# ETHOS URBAN

## Response to Public Individual Submissions

Redevelopment of Greenwich Hospital

27 September 2019 | 2190376

2 EQUINOX SOLSTICE 21ST MAR 3PM - PROPOSED
1:1000

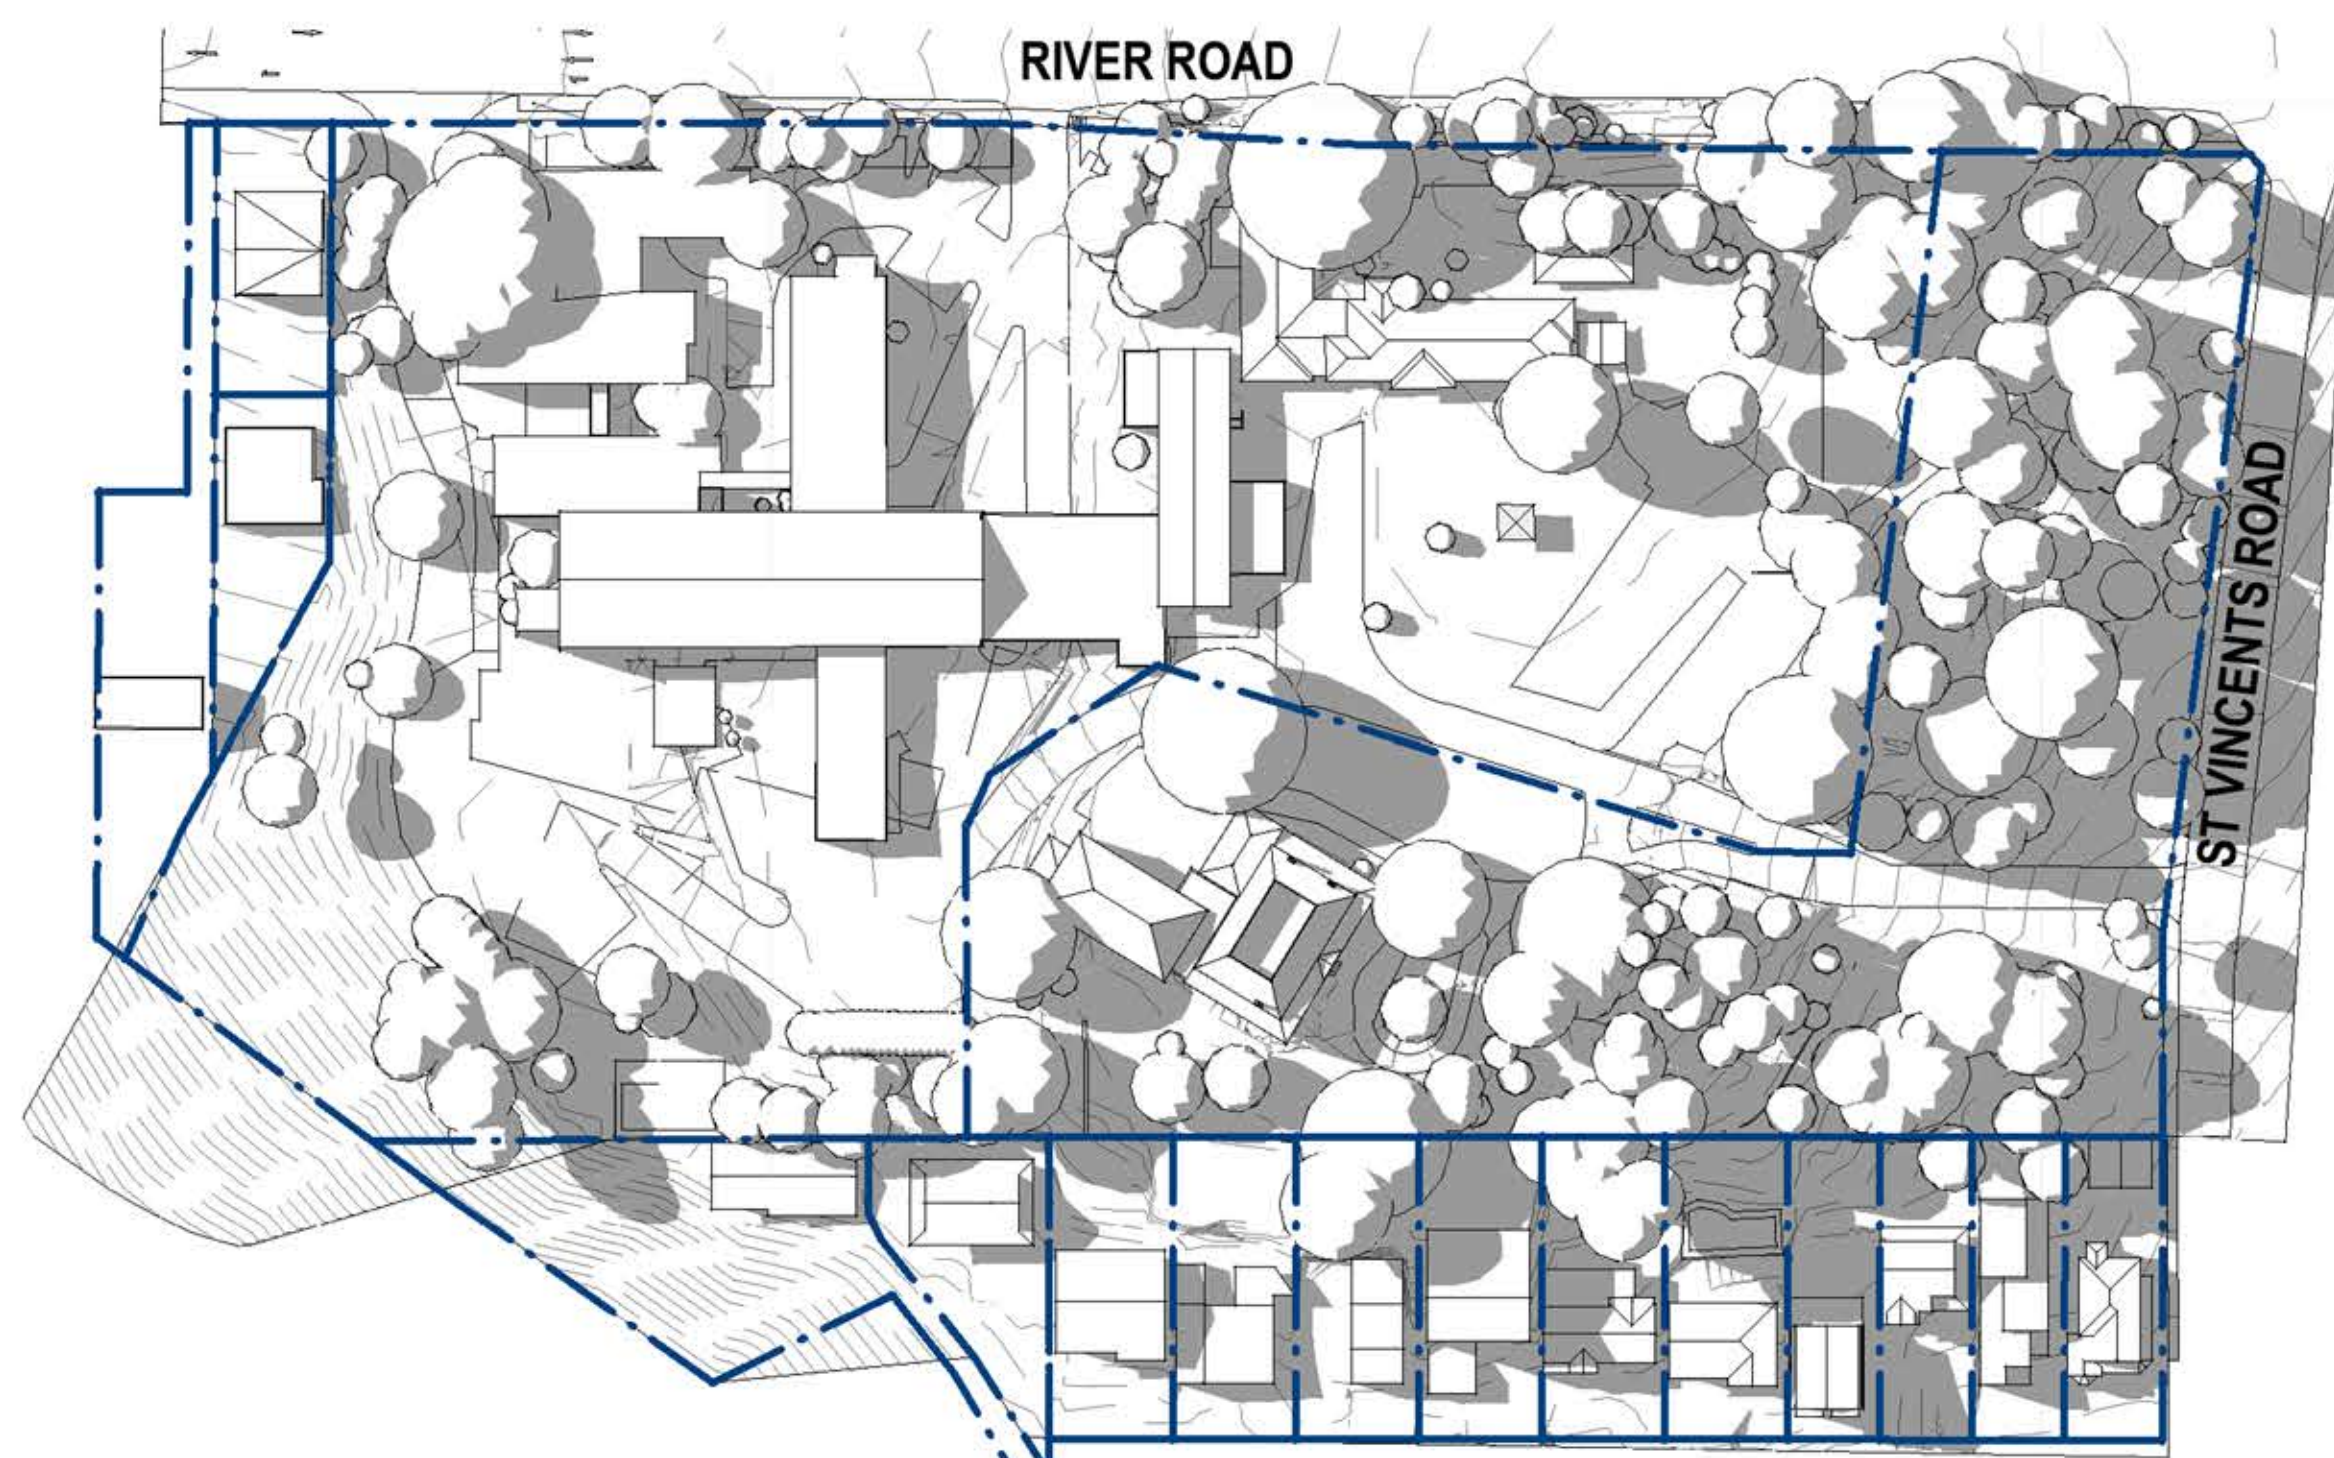
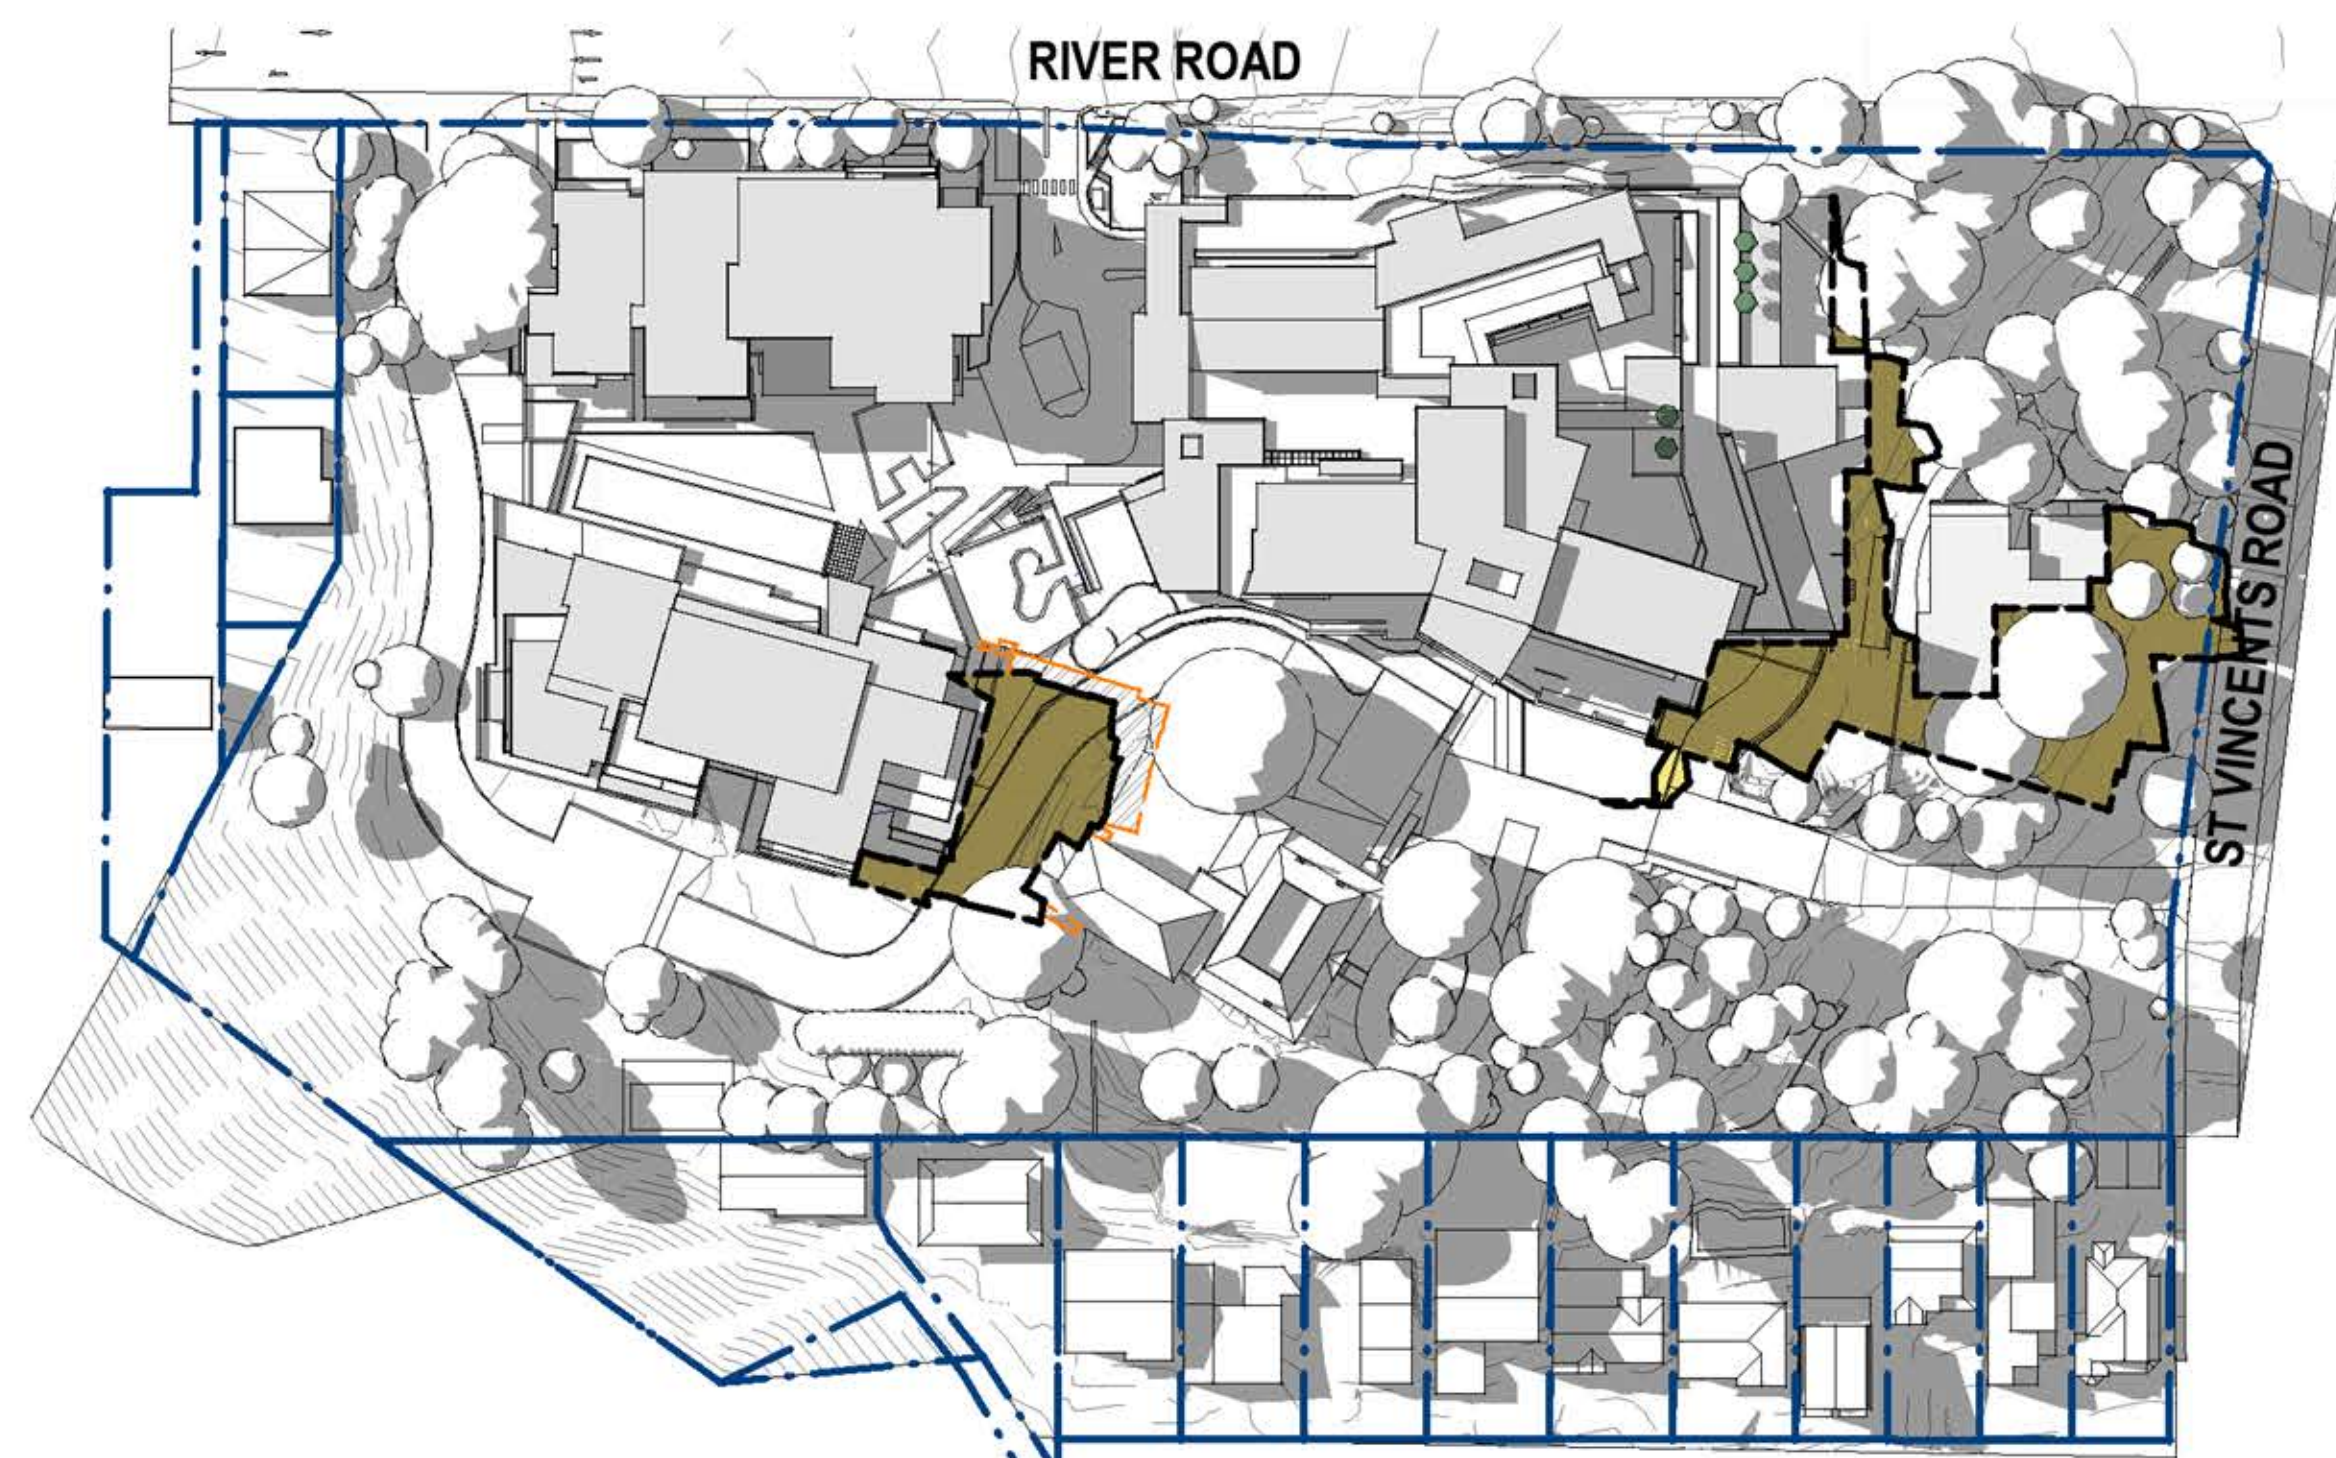
<b>Overshadowing</b>		
The development will result in excessive overshadowing	Shadow diagrams have been supplied as part of the Amended Architectural Plans prepared by Bickerton Masters at <b>Appendix A</b> of the RTS, demonstrating that only minimal overshadowing will be generated by the proposed redevelopment outside of the site.	12
Overshadowing onto Bob Campbell Oval	Shadow diagrams have been supplied as part of the Amended Architectural Plans prepared by Bickerton Masters at <b>Appendix A</b> of the RTS, demonstrating that no overshadowing will occur onto Bob Campbell Oval.	11
Overshadowing onto Gore Creek Bushland Reserve	Shadow diagrams have been supplied as part of the Amended Architectural Plans prepared by Bickerton Masters at <b>Appendix A</b> of the RTS, demonstrating that no overshadowing will occur onto Gore Creek Bushland Reserve.	7
<b>Traffic and Parking</b>		
Insufficient parking has been proposed	A Traffic and Parking Impact Assessment was submitted with the original application which concludes the proposed provision of parking is appropriate. Parking for the seniors living component complies fully with the rates stipulated in SEPP Seniors, with one space per unit plus additional visitor spaces; 163 parking spaces are proposed for the hospital to service the 150 beds/rooms. Public transport options are also available for the site, meaning a proportion of visitors will not elect to drive.	15
